RE: SSD-5544-Mod-7 Kurnell Refinery Conversion - Infrastructure consolidation and remediation

Thank you for notifying Sydney Water of SSD-5544-Mod-7 at Kurnell Terminal, which proposes preparation works, removal/relocation/augmentation of infrastructure, remediation works, grading of land, including construction of OSD basins, and demobilisation works. These works will allow for the continued operation of the Kurnell Terminal while preparing the land for future uses. Sydney Water has reviewed the application based on the information supplied and provides the following Sydney Water requirements to assist in understanding the servicing needs of the proposed development.

Figure 2: The Proposed Modification

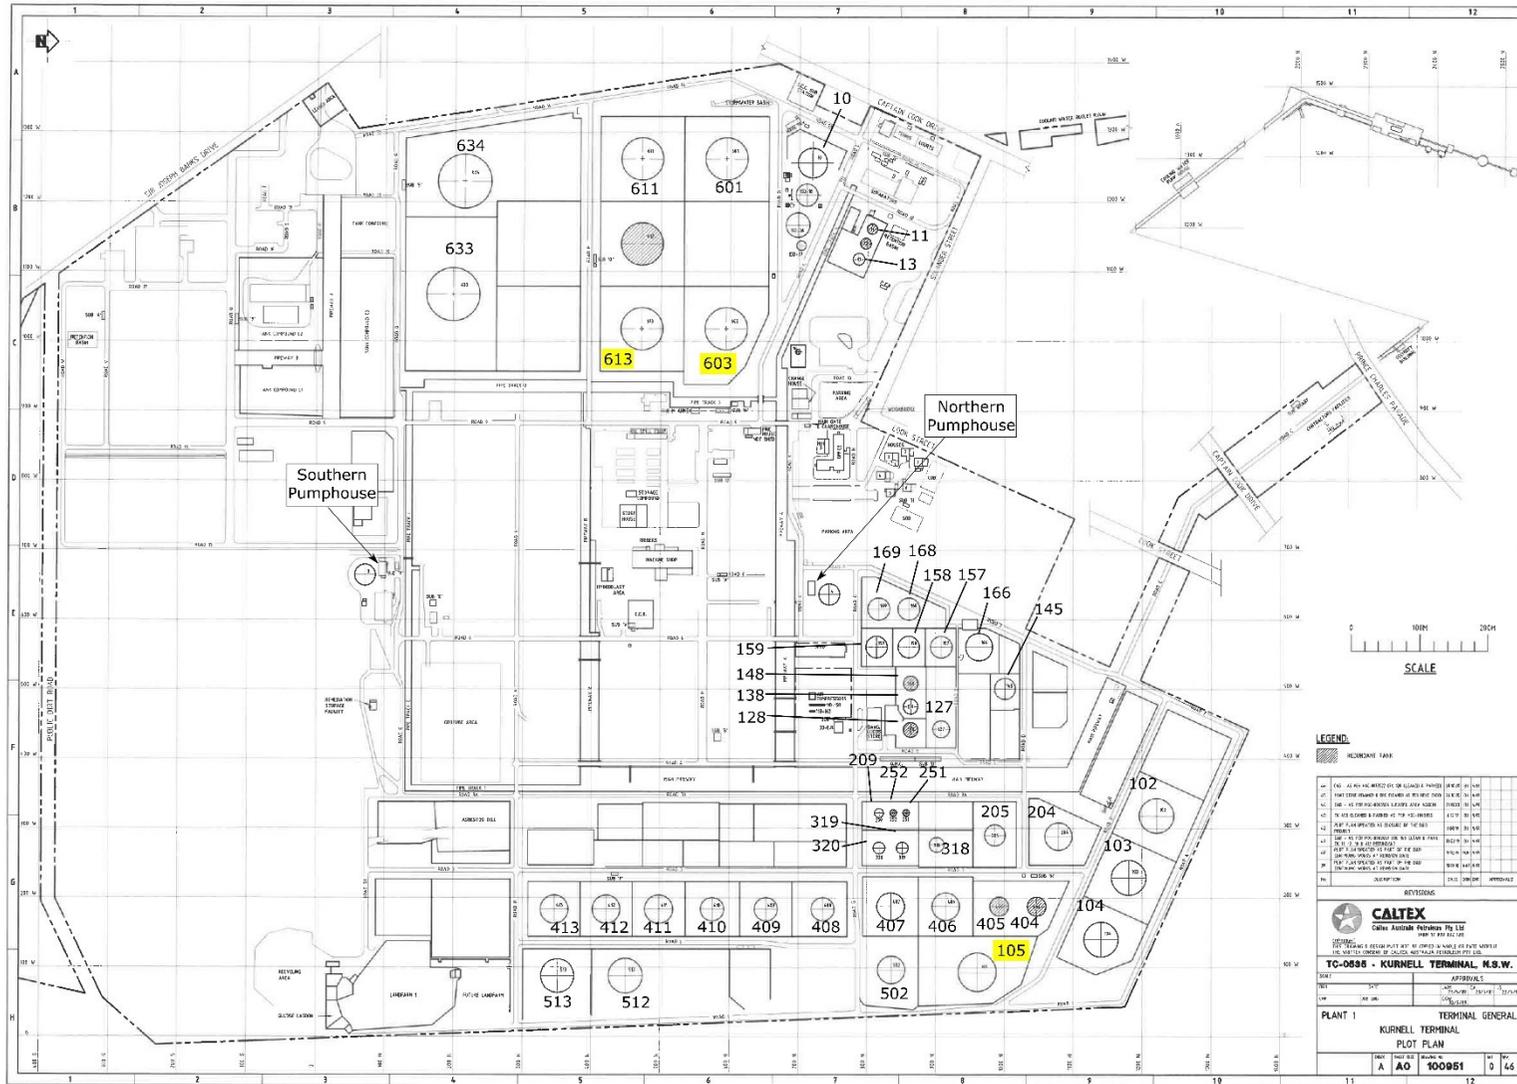
The Sydney Desalination Plant pilot pipeline appears to be located along the southern boundaries of Lot 2 DP 215818 and Lot 1 DP 215818 (Zone 3). The proposed earthworks and construction of an OSD may impact this pipeline. Sydney Water recommends the Department of Planning, Housing and Infrastructure (the Department) and the applicant contact Sydney Desalination Plant for commentary on the proposal if they have not done so already.
